## Application for a Non-Material Amendment Following a Grant of Planning Permission

Land Adj. 62 Water Gate, Quadring, Spalding.

Erection of 7 detached dwellings

H15-0865-24

Drawing
Single Garage
1:50 @ A2

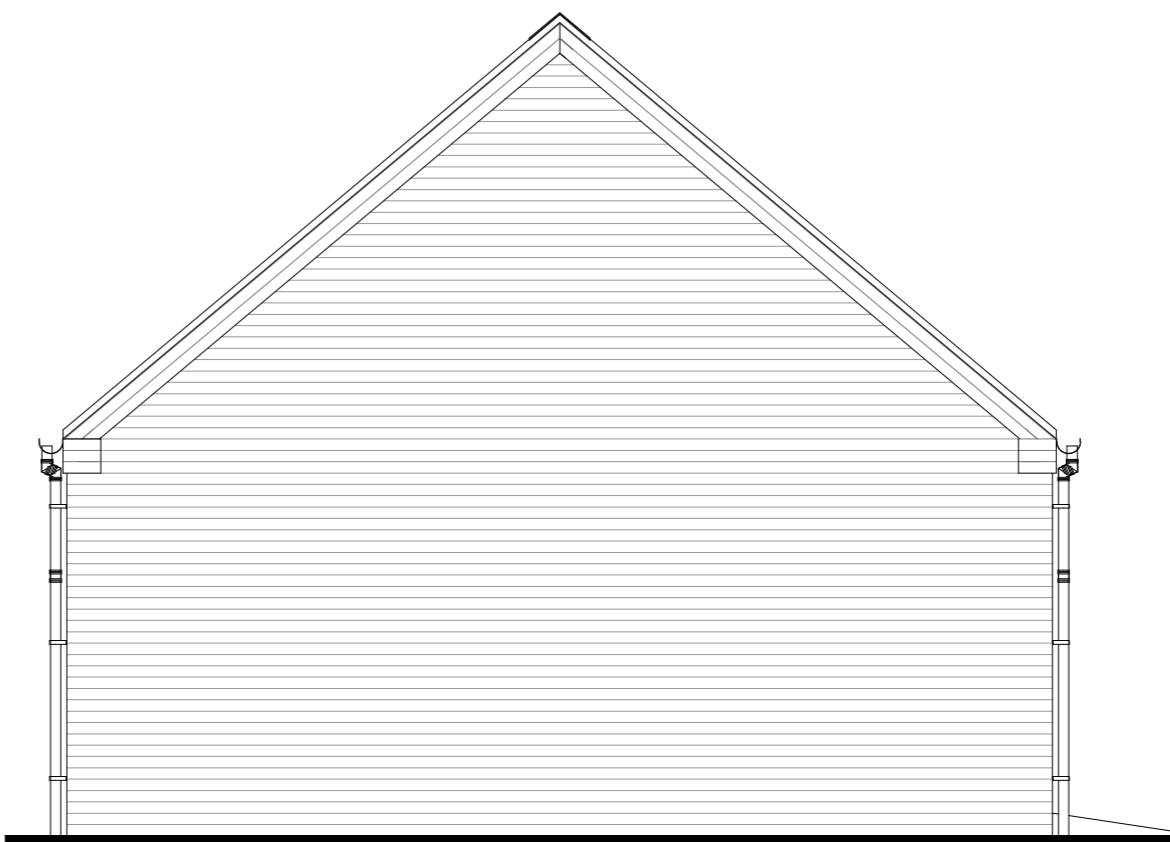
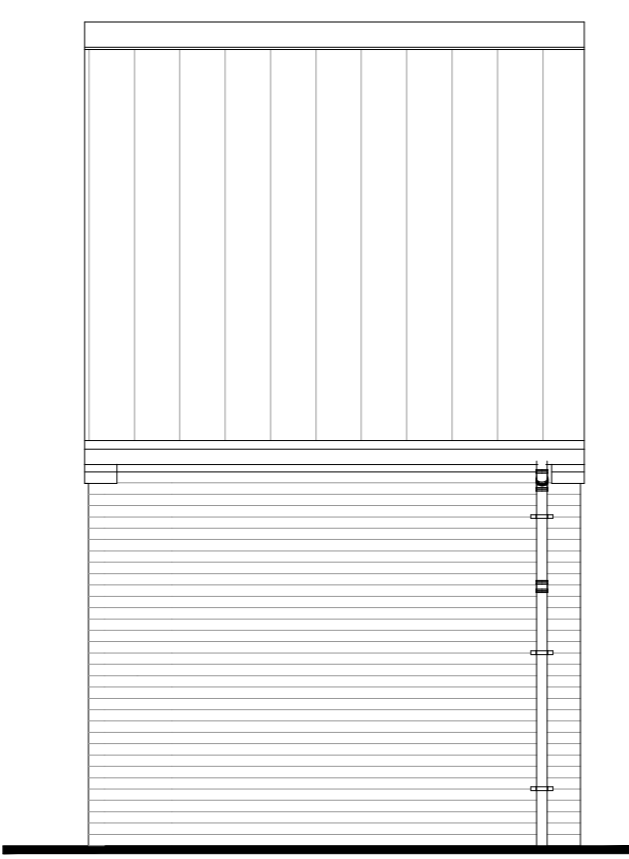
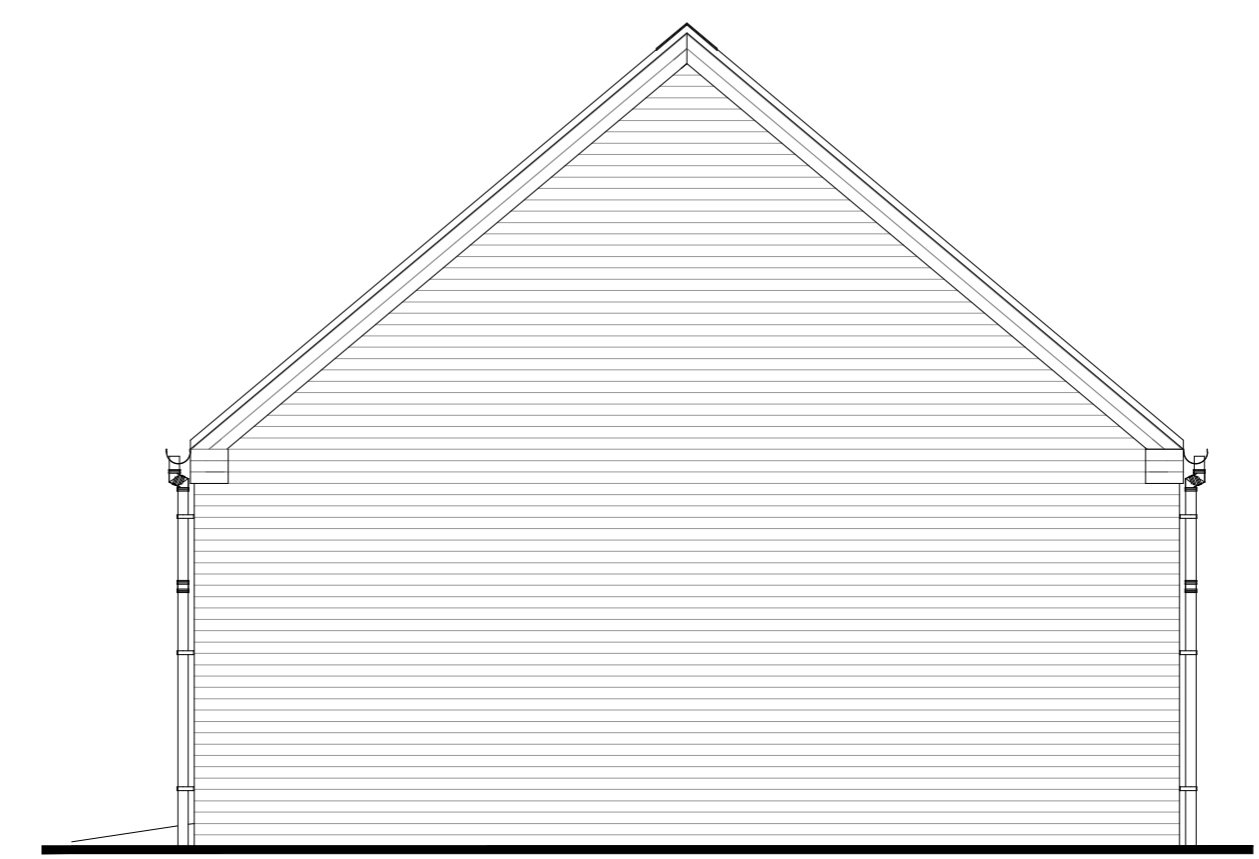
Replacement of stone window and door heads for 215mm brick soldier courses.

QUA24-COR-XX-ZZ-DR-A-0001 Rev P03  
QUA24-COR-XX-ZZ-DR-A-002 Rev P03  
QUA24-COR-XX-ZZ-DR-A-0003 Rev P03  
879-2-DG1A Single Garage  
879-2-DG2A Double Garage
